Rezoning Transportation Analysis
Petition Number: Insert Zoning Petition #2021-063
General Location Identifier: 14124101

Revision Log:	Date	Description
	05-27-2021	First Review (KP)

General Review Information

SITE PLAN

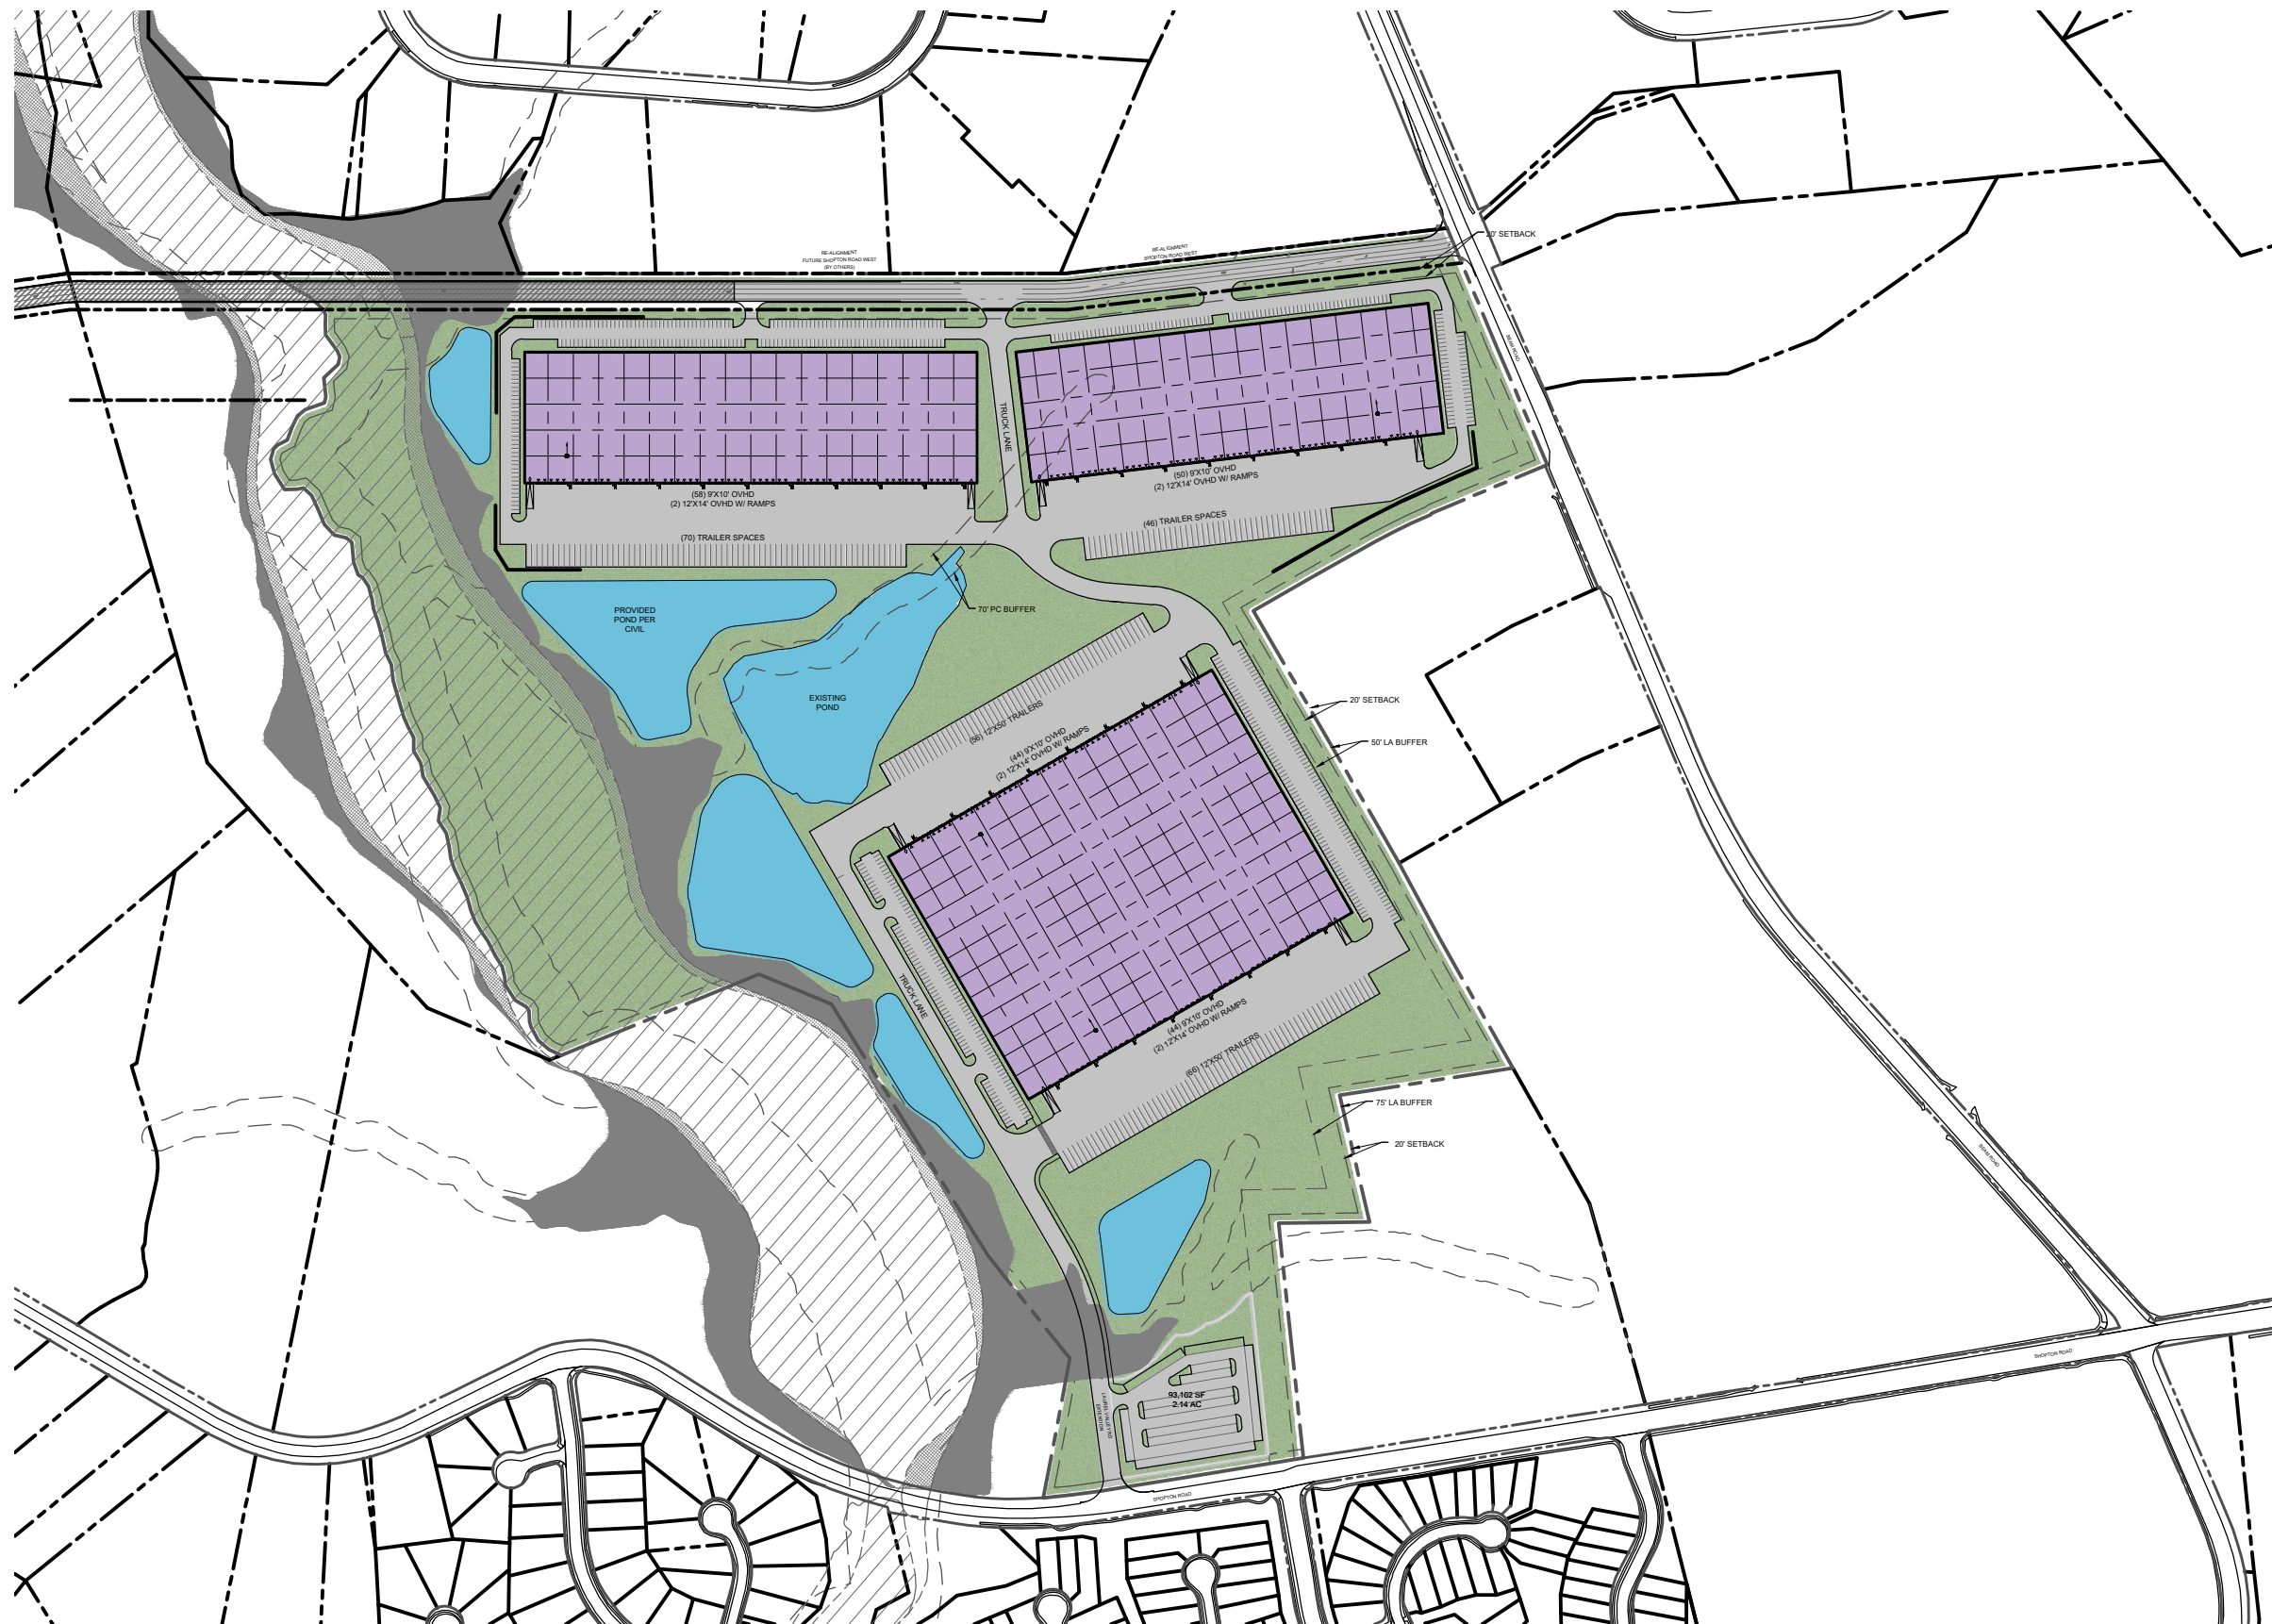
1. Curblines:

- a. **Shopton Road:** The location of curb and gutter will be placed 27-feet from the existing road centerline to back-of-curb.
- b. **Beam Road:** The location of curb and gutter will be placed 38-feet from the existing road centerline to back-of-curb.

Label and dimension the curb and gutter from the centerline for each road on the site plan.

3. Right-of-way:

- a. **Shopton Road:** Revise site plan and conditional note(s) to commit to dedicate 43-feet of right-of-way from the road centerline.
- b. **Beam Road:** Revise site plan and conditional note(s) to commit to dedicate 56-feet of right-of-way from the road centerline.

The site plan shall label and dimension the right-of-way from the road centerline.

- 4. Revise site plan and conditional note(s) to commit to construct an 8-foot planting strip, and 6-foot sidewalk along the site's frontage of Shopton Road and Beam Road, per City Ordinance - Chapter 19. The site plan shall label and dimension both items from the existing road centerline.

- 5. Revise the site plan and conditional notes to commit to constructing 8-foot buffered bike lanes (3-foot buffer and 5-foot lane) along the site's frontage of Shopton Road and Beam Road. The site plan shall label and dimension the bike lane from the existing centerline of each road.

- 6. Revise the site plan and conditional notes to commit to constructing a left-turn lane **and** right-turn lane, with 150-feet of storage and appropriate bay-taper length, at the proposed site entrance located on Beam Road. Additionally, include in the conditional note that the turn lanes will be designed and striped in accordance with the City of Charlotte's Pavement Marking Guidelines.

7. Revise the site plan and conditional notes to commit to widen Beam Road 38-feet from the existing centerline to back-of-curb, along the site's frontage. Additionally, revise the striping along Beam Road to incorporate a three-lane section with the buffered bike lanes striped along the edge-of-pavement. Any additional asphalt shall utilize transverse striping, in accordance with the City's Pavement Marking Standards, to delineate the travel lane and the buffered bike lane.

8. Revise the site plan and conditional notes to commit to constructing a left-turn lane **and** right-turn lane, with 150-feet of storage and appropriate bay-taper length, at the proposed site entrance located on Shopton Road. Additionally, include in the conditional note that the turn lanes will be designed and striped in accordance with NCDOT's Roadway Design Manual.

9. Revise the site plan and conditional notes by committing to coordinate driveway location and site access associated with PID# 14106101. CDOT recommends moving the driveway location to the

proposed segment of the Shopton Road Extension. The driveway location will be subject to CDOT approval during the permitting process.

- 10. Revise the site plan and conditional notes to commit to construct a portion of the Shopton Road Extension CTP Alignment, as generally depicted on the site plan. Additionally, provide the cross section, associated with the Shopton Road Extension, that includes dimensions of the proposed infrastructure and the right-of-way to be dedicated to CDOT.

- 11. Revise the site plan and conditional notes by committing to dedicate the right-of-way for the future segment the Shopton Road Extension, that will not be constructed with this development, to CDOT. The amount of right-of-way dedication should be proportionate with the cross section established in Note 10 of this memo.

12. Revise the site plan and conditional notes to commit to coordinate with Mecklenburg County Parks and Recreation and construct the portion of the Coffee Creek Greenway that extends through this site.
